## Parks and Wildlife

May 22, 2022

Re: DeYoung RV Storage

Colorado Parks and Wildlife (CPW) has reviewed the plans for the DeYoung RV Storage in El Paso County, Colorado in the area north of Woodmen Road at Bent Grass Meadows Dr. Colorado Parks and Wildlife (CPW) is in receipt of the above referenced permit application and is familiar with the site. This area included within the development boundaries will sustain numerous wildlife species including deer, pronghorn, turkey, coyote, fox, raptors, songbirds, and numerous small mammals. CPW makes the following recommendations.

7 WROUGHT IRON FENCE DETAIL
SCALE: 1/2"=1'-0"

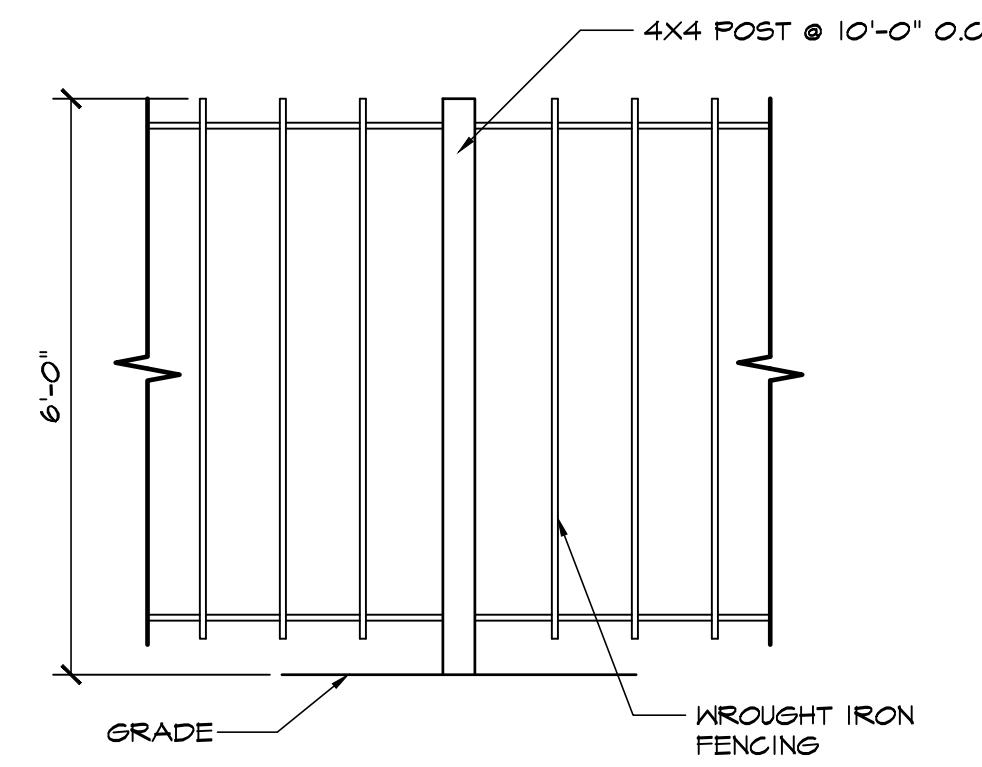
As for more general construction protocols, CPW recommends low speeds for construction vehicles to avoid wildlife collisions. If any temporary (e.g., construction) or permanent fencing is proposed, CPW recommends that it is the wildlife-friendly fencing that allows young to cross, and does not include high-tensile hogwire.

Fences can cause many problems for wildlife, including death, entanglements, and barriers to movements. CPW recommends the developers consult our publication Hanophy, Wendy “Fencing with Wildlife in mind.” CPW.state.co.us. 2009 when considering the design of fences within the development. The publication is available on our website and we would be happy to provide a link to the PDF specifically. The use of privacy fencing, chain link fencing, and other exclusionary fencing should be at least 6 feet high and should be restricted to the immediate area surrounding the buildings or within the designated building envelope and should not be used as a method to designate boundaries of larger lot sizes (> 1 acre). Fencing outside the immediate building envelope or area surrounding the buildings on larger lots within the known range of elk, deer and pronghorn should be a maximum top height of 42” with at least 12” spacing between the top two wires or rails and a bottom wire or rail at least 16” above the ground to allow passage of juvenile animals and pronghorn antelope.

It is also recommended that the top and bottom wires be a twisted barbless type or smooth wire or rail construction. Construction of ornamental wrought iron fencing with closely spaced vertical bars (<12”) and sharp projections extending beyond the top horizontal bar should be strongly discouraged in areas where deer, elk, and black bear are known to occur. This type of fencing typically ensnares deer and elk by the hips when trying to squeeze through and impales animals attempting to go over the top. It should be noted that it is very distressing to find wildlife in or impaled on fences.
